DEVELOPMENT REVIEW BOARD--SPEED MEMO

CITY OF ALBUQUERQUE
PLANNING DEPARTMENT
Development Review Board
April 28, 2004
Comments

Re: Lot 3A2B, Block 1, Sunport Park Building Shell/SPBP

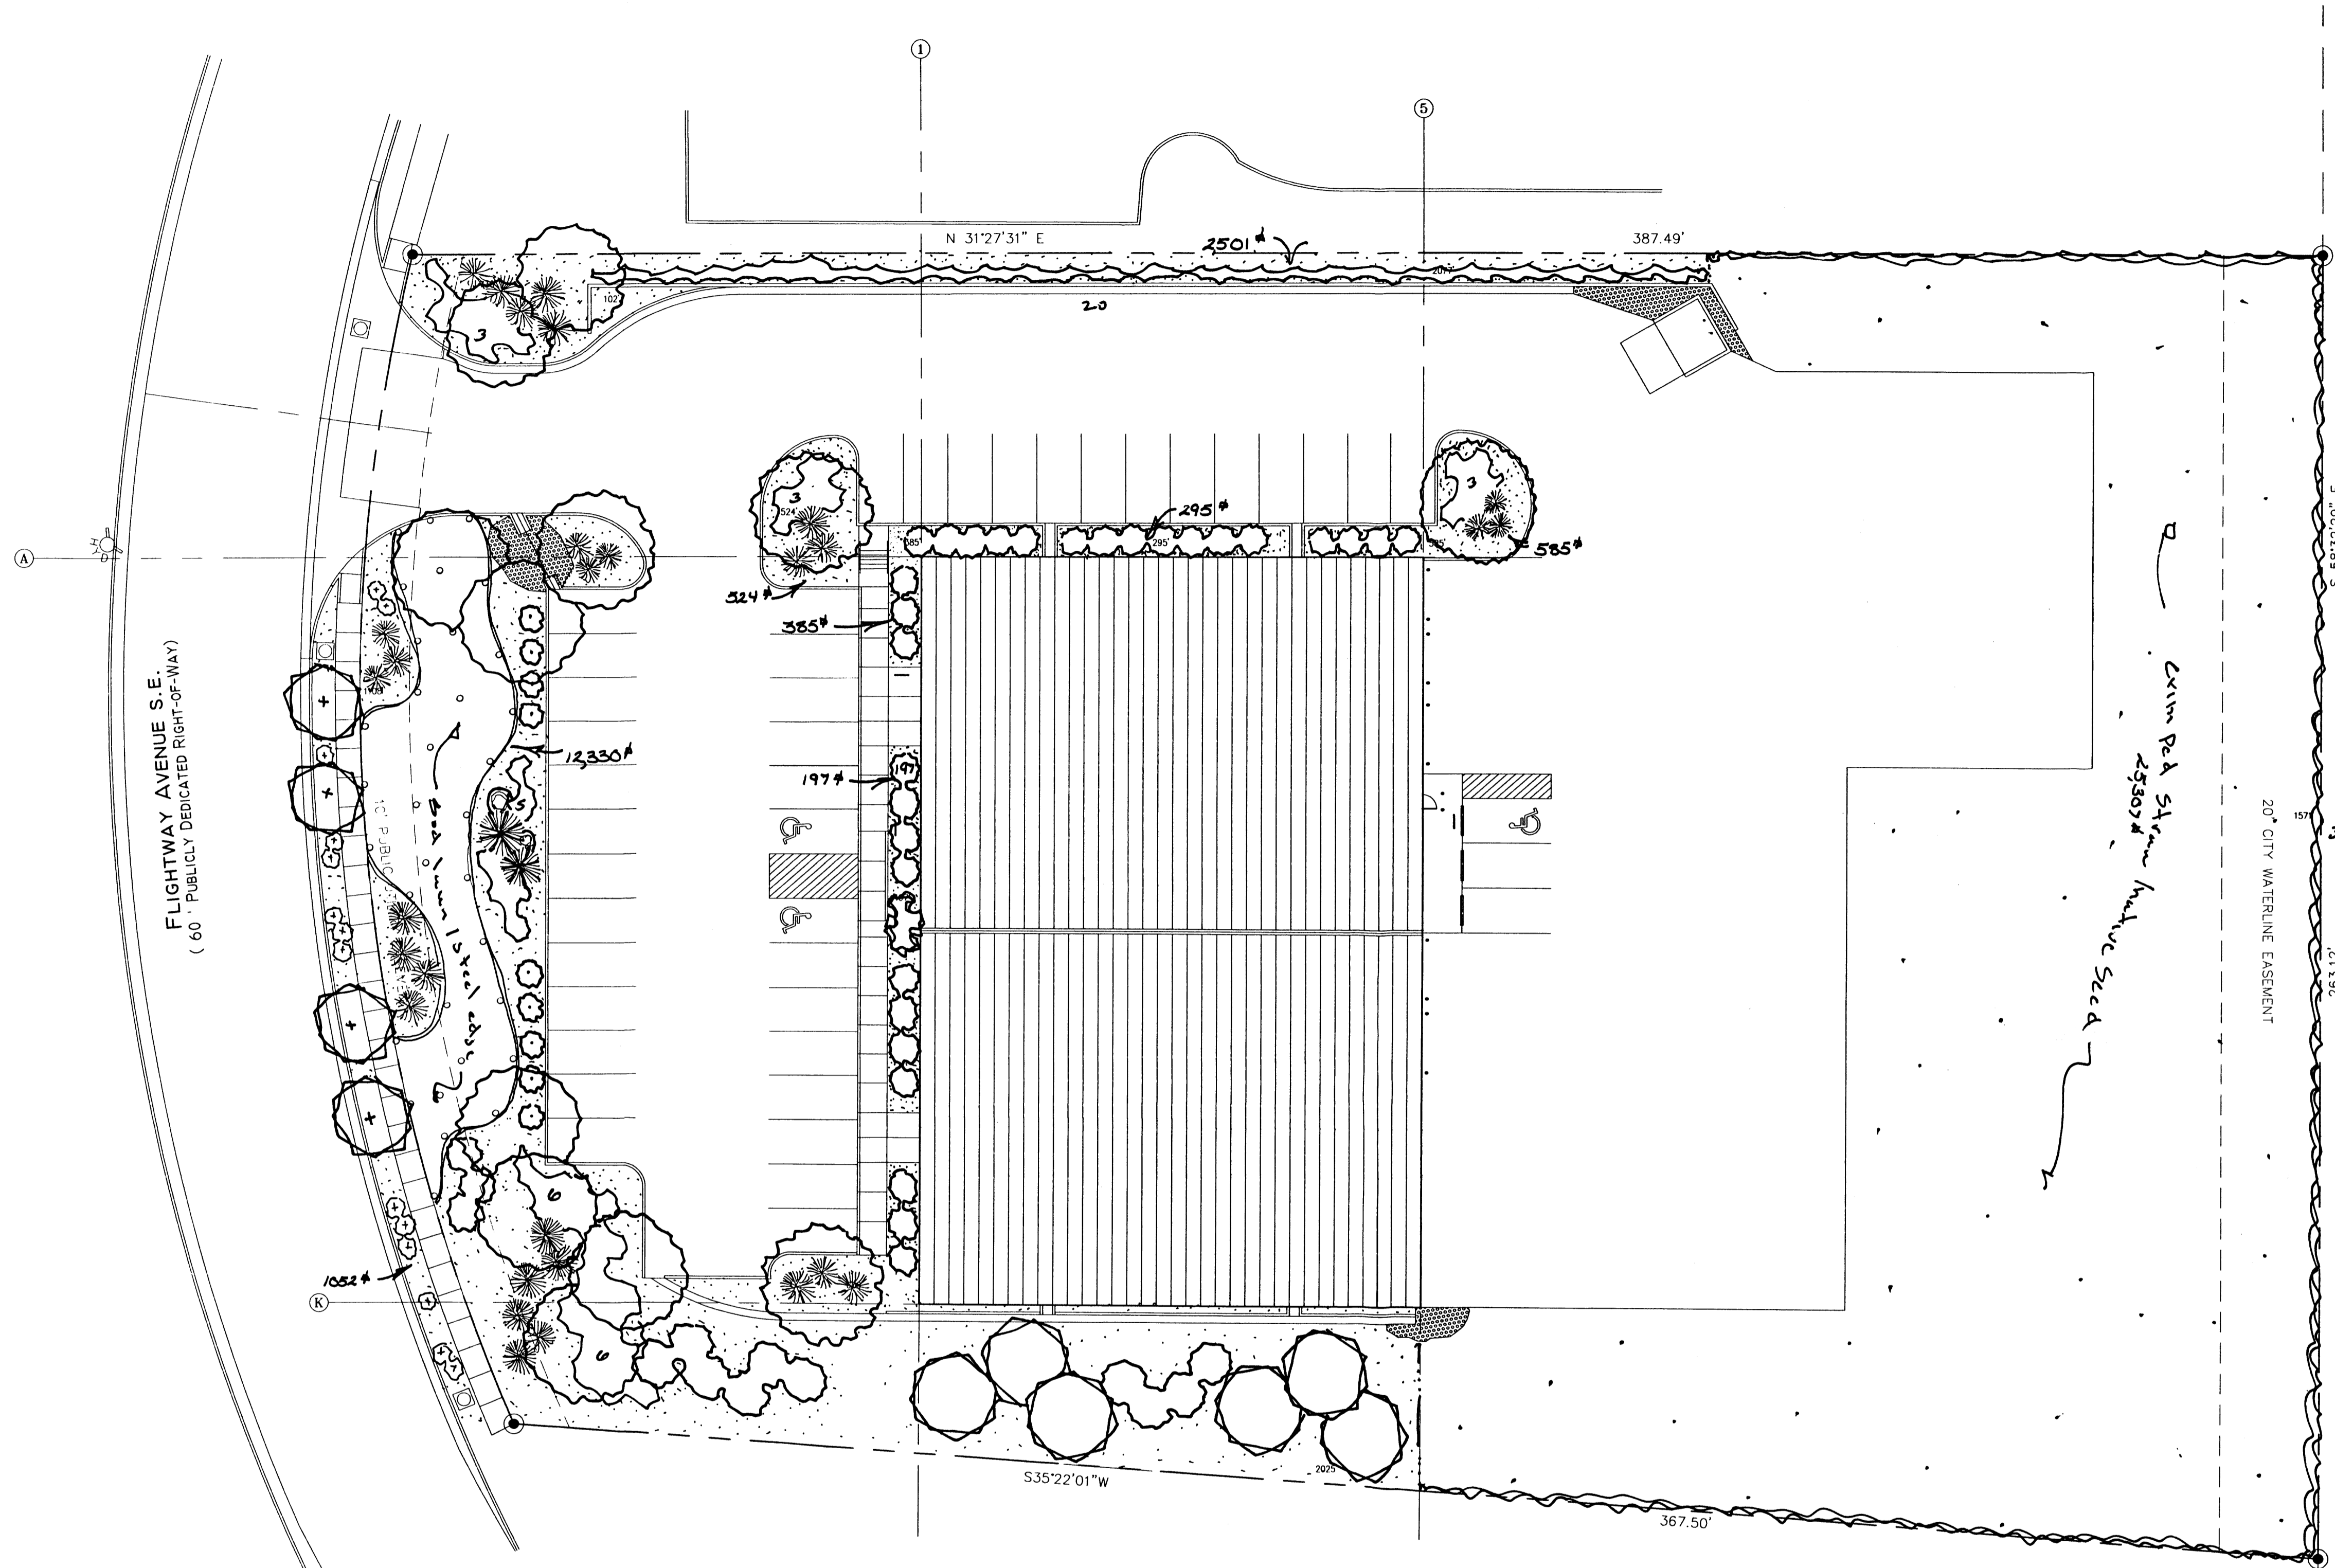
Landscape Plan. The junipers should be removed as they are a high allergen plant.
